DEVELOPMENT REVIEW BOARD
SUPPLEMENTAL SUBMITTAL

PROJECT NO. 2022-006547

DESCRIPTION: DRB - Site planning 2nd resubmittal city comments response

RE: Panda Express – S8-22-D8582
10126 Coors Blvd. NW
Albuquerque, NM 87114
RE: DRB Planning Review – 2nd Resubmittal
DRB Project Number: 2022-006547
App. Number: SI-2022-00216

GENERAL NOTES AND CONSTRUCTION NOTES

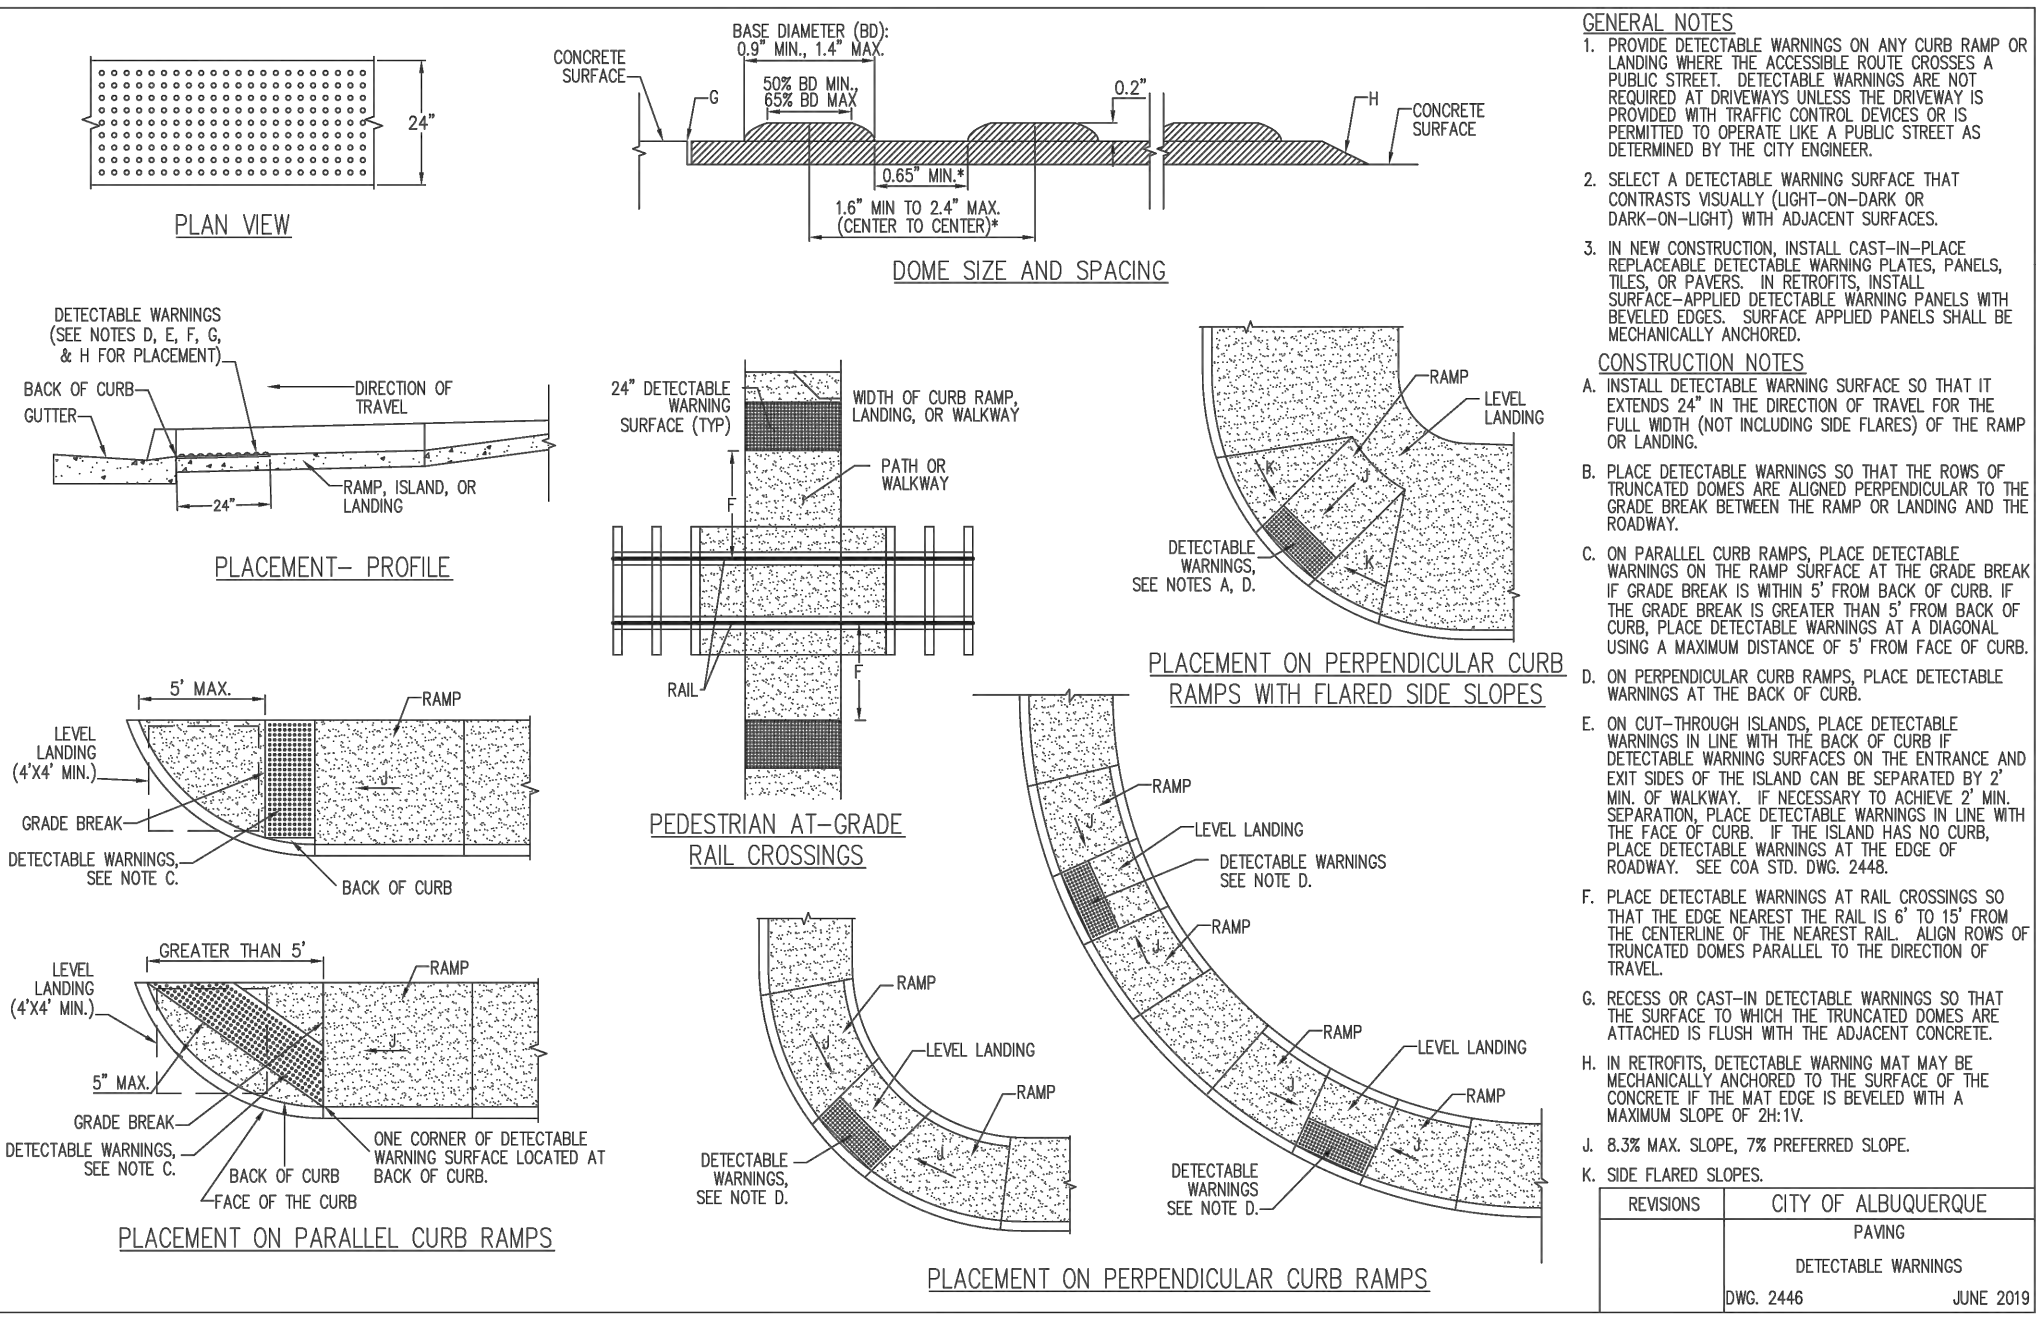
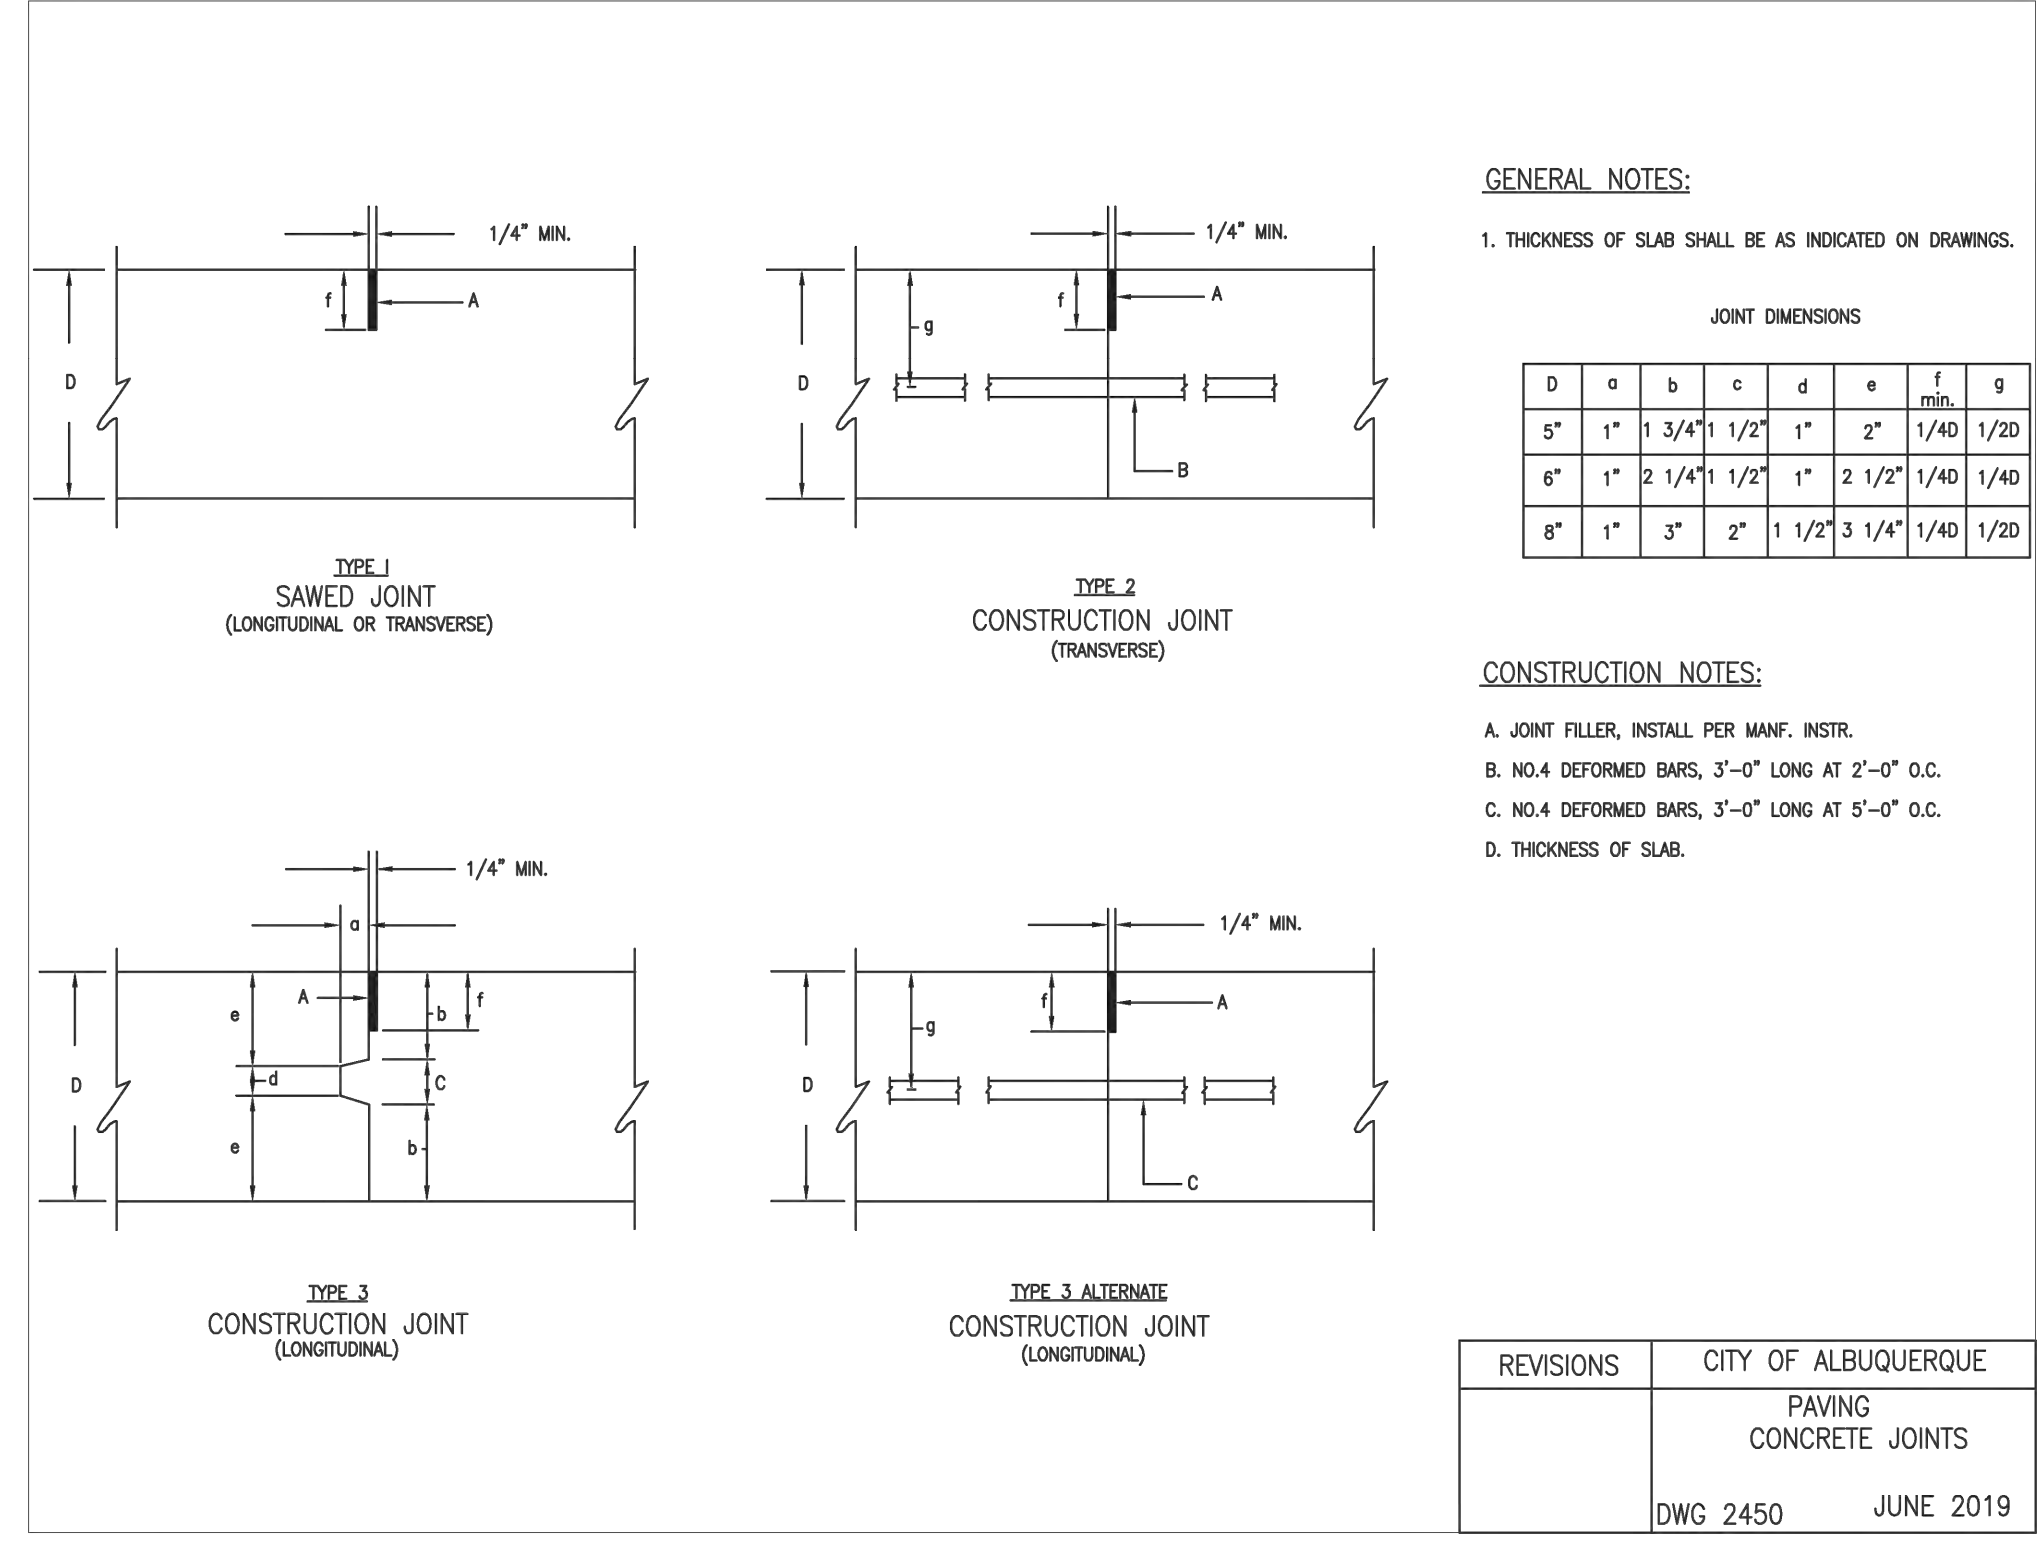
7. The ADA accessible parking sign must have the required language per 66-7-352.4C NMSA 1978 “**Violators Are Subject to a Fine and/or Towing.**” If that language is present it is not visible in the detail.

8. Motorcycle and bicycle parking details are needed. These shall include bike rack details and motorcycle parking signage details.

Response: Noted, see updated detail 5 on sheet C03.2

Response: Noted, see detail 4 on sheet C03.3 and detail 1 on sheet C03.4 SIGN
